East Anglia One North (EA1N) and East Anglia Two (EA2) Offshore Wind Farms

Planning Inspectorate Reference: EA1N – EN010077 & EA2 – EN010078

Deadline 5 - 3 February 2021

**East Suffolk Council's Response to Examining Authority's Action Points Following
Issue Specific Hearings 3, 4, 5 and 6**

200

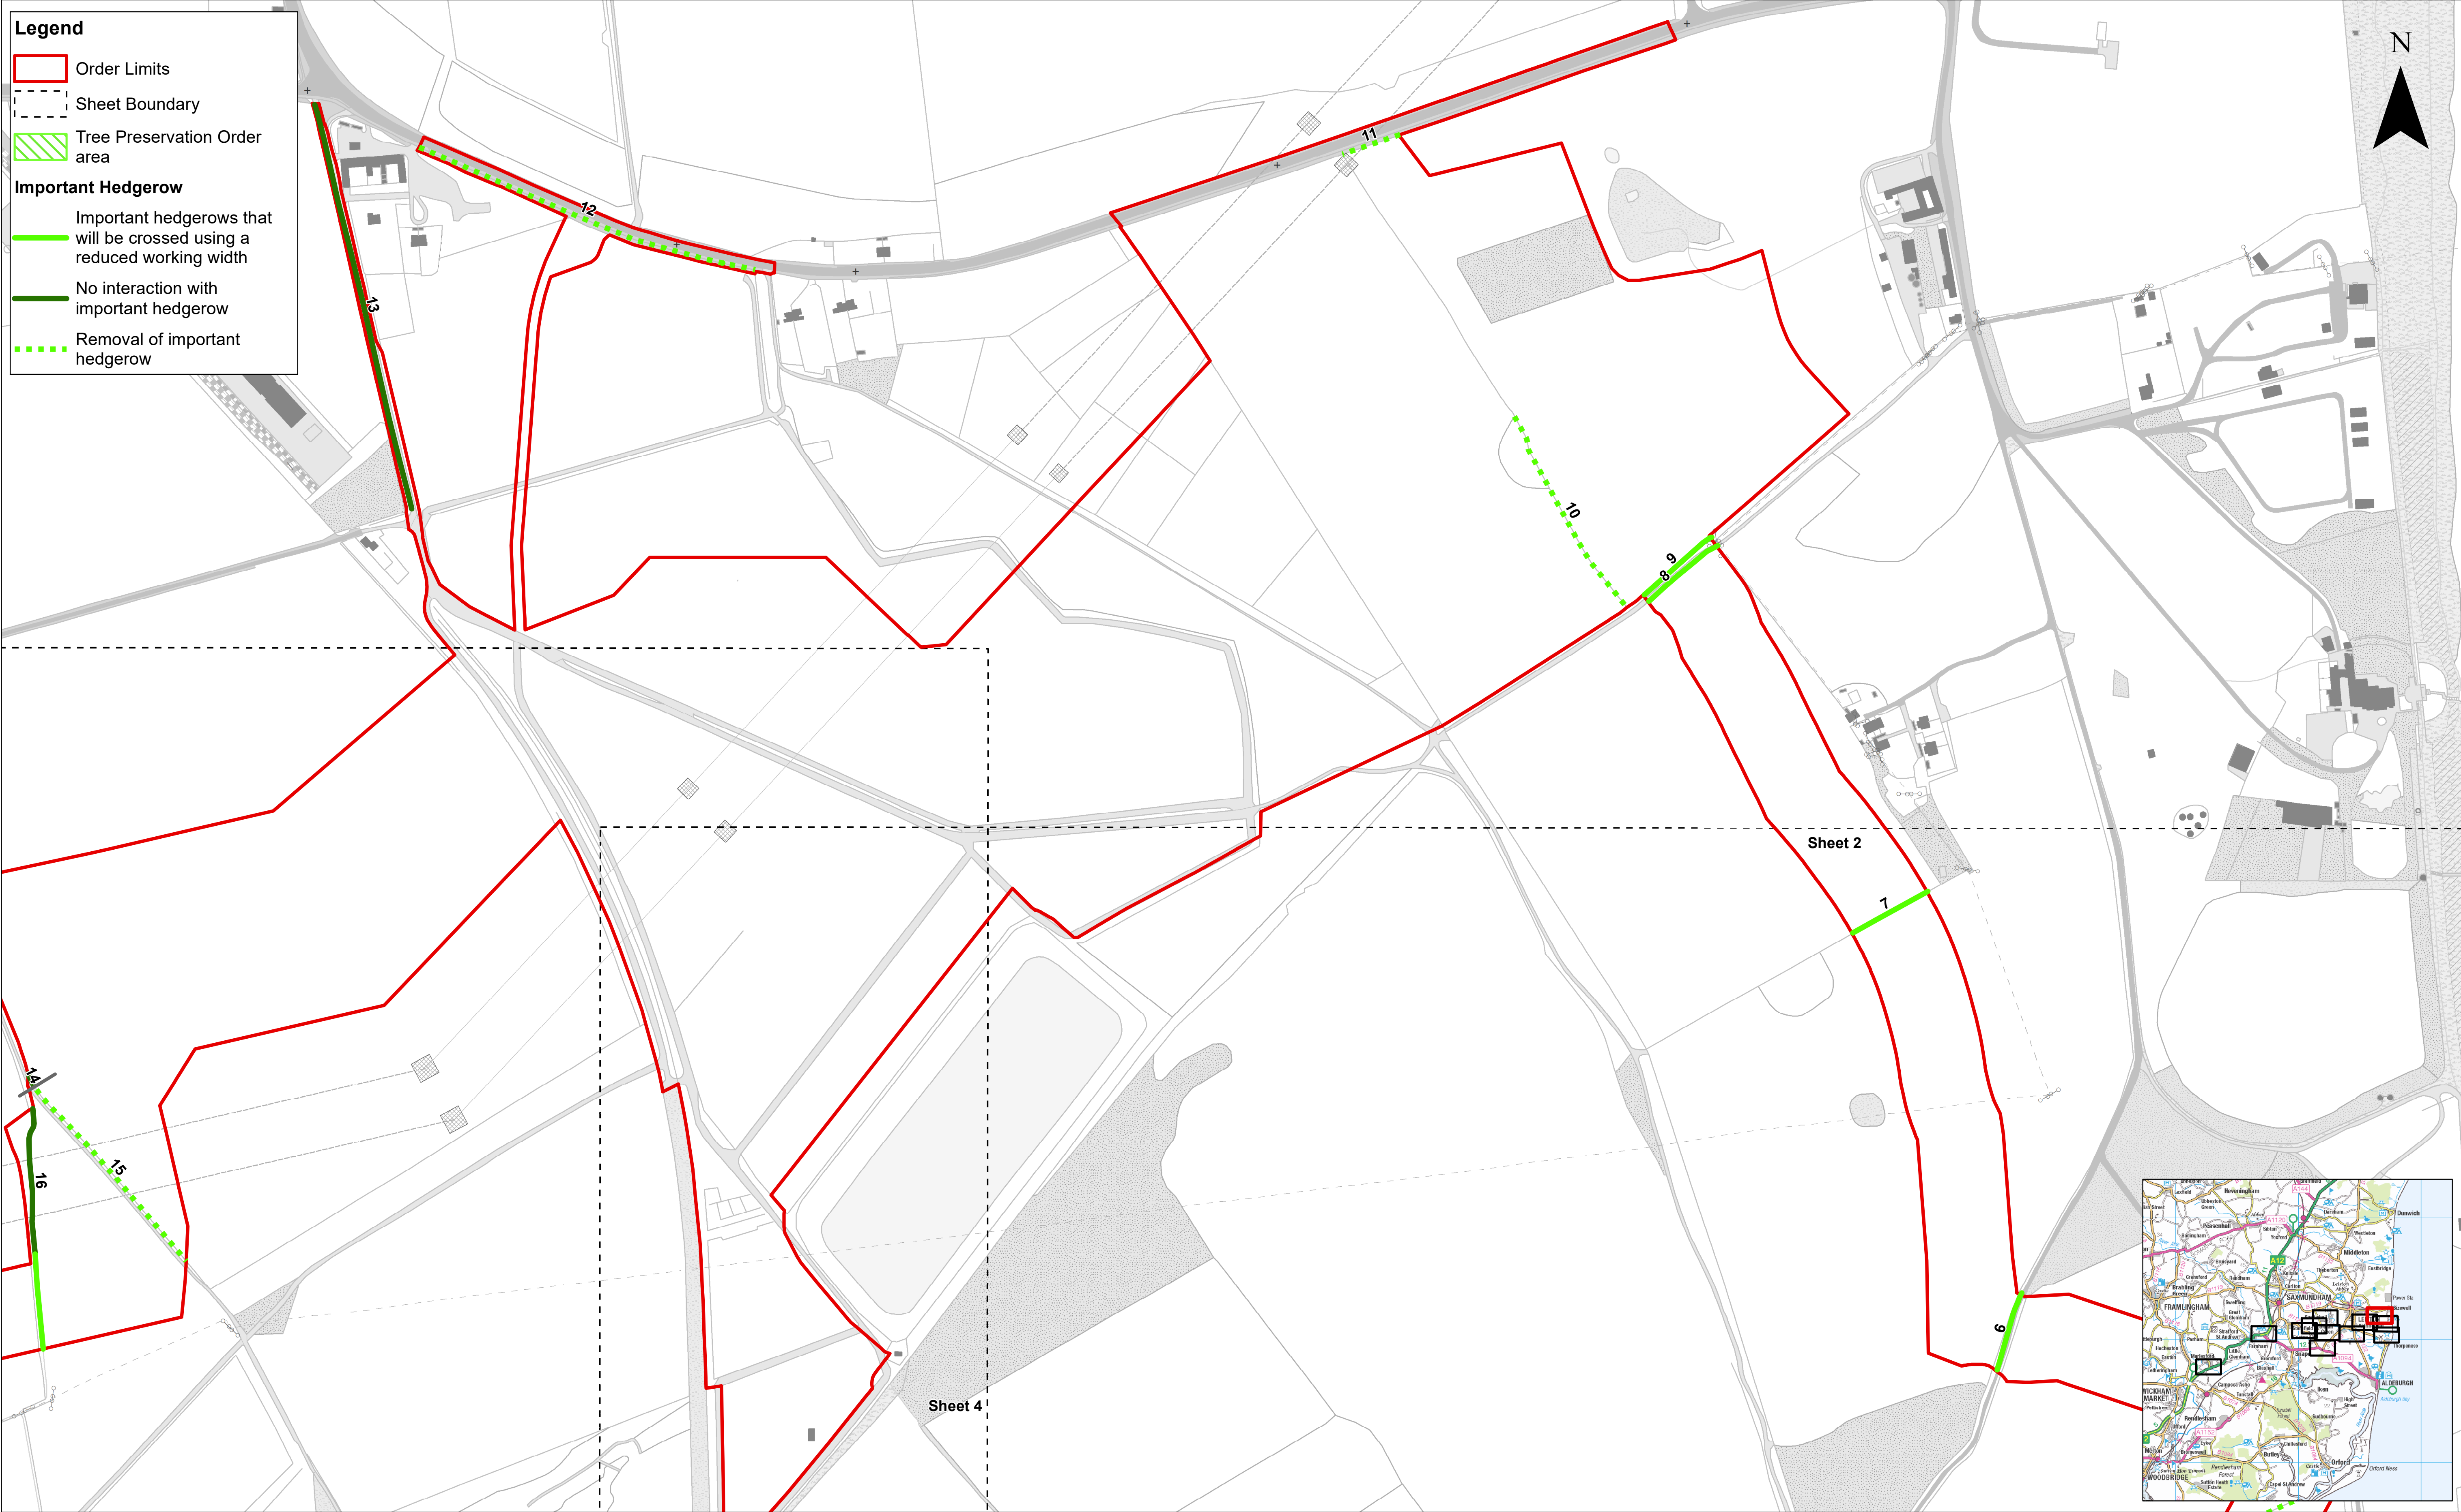
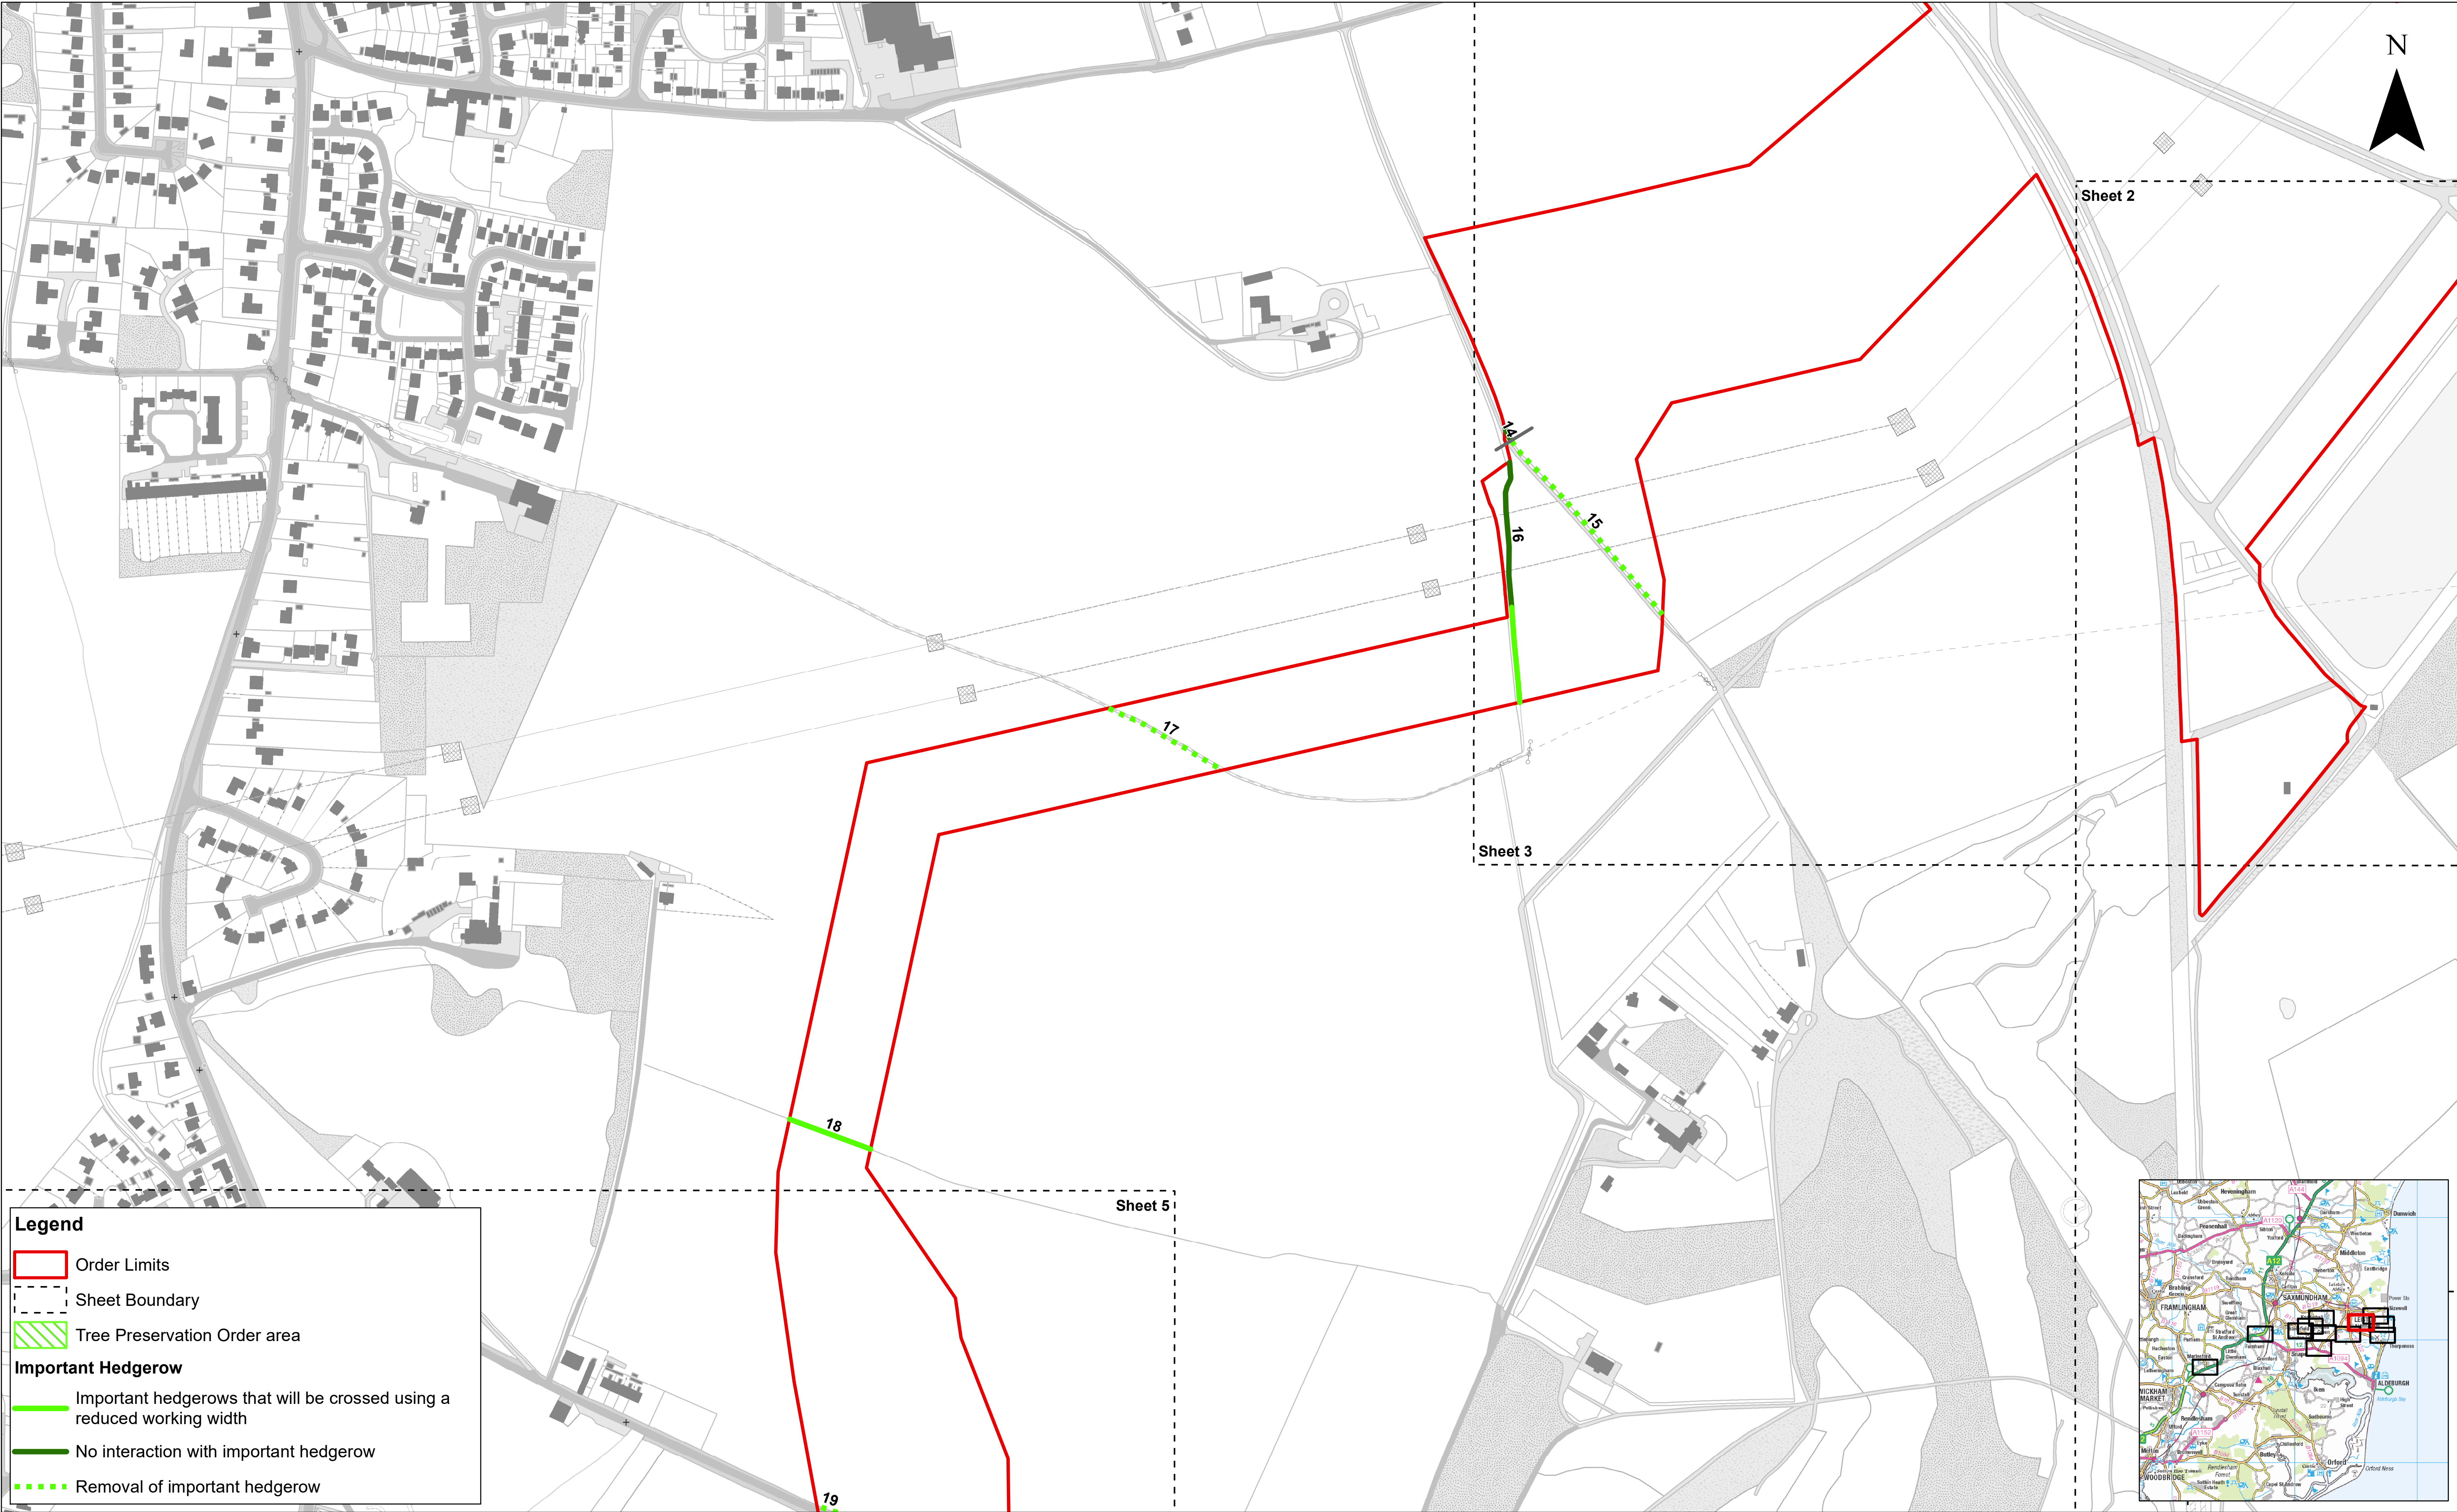
<p>ESC has been in discussion with the Applicants in relation to the removal of land parcel no.3 from the draft DCOs.</p> <p>Schedule 8 – Modification of compensation and compulsory purchase enactments for creation of new rights and imposition of new restrictions – ESC has no comments.</p> <p>Schedule 9 - Land of which temporary possession may be taken.</p> <p>ESC has been in discussion with the Applicants in relation to the removal of land parcel no.3 from the draft DCOs.</p> <p>Schedule 10 – Protective provisions – ESC has no comments.</p> <p>Schedule 11 - Hedgerows</p> <p>ESC seeks clarity regarding the hedgerows identified within Schedule 11 of the draft DCOs.</p> <p>Hedgerows marked 1 and 2 are identified within Schedule 11 (REP3-011) as being removed but on the Important Hedgerows and Tree Preservation Order Plan (REP3-010) they are identified as being crossed with a reduced width. Annex 1 of the OLEMS document (REP3-030) identifies hedgerows 1 and 2 as being subject to full or partial removal. Clarification on this is required.</p>

<p>Clarification is also required in relation to hedgerow marked 28 which is identified on the Important Hedgerows and Tree Preservation Order Plan (REP3-010) as being removed but is not identified within Schedule 11 as being removed and identified in Annex 1 of the OLEMS (REP3-030) as not subject to interaction.</p> <p>The interaction identified within Annex 1 of the OLEMS (REP3-030) in relation to a number of hedgerows does not appear to correspond to the interaction identified within Schedule 11 of the draft DCOs (REP3-011) and the interaction identified on the Important Hedgerows and Tree Preservation Order Plan (REP3-010). Further clarification as to the reasons for this is required. Does Annex 1 identify a greater number of important hedgerows to be crossed with a reduced width as some of these will be crossed with a width less than 32m but greater than the draft DCOs definition of reduced width which is 16.1m?</p> <p>Schedule 12 – Trees subject to tree preservation orders – ESC has no comments.</p> <p>Schedule 13 – Deems licence under the 2009 Act – generation assets – ESC has no comments.</p> <p>Schedule 14 – Deemed licence under the 2009 Act – offshore transmissions assets – ESC has no comments.</p>
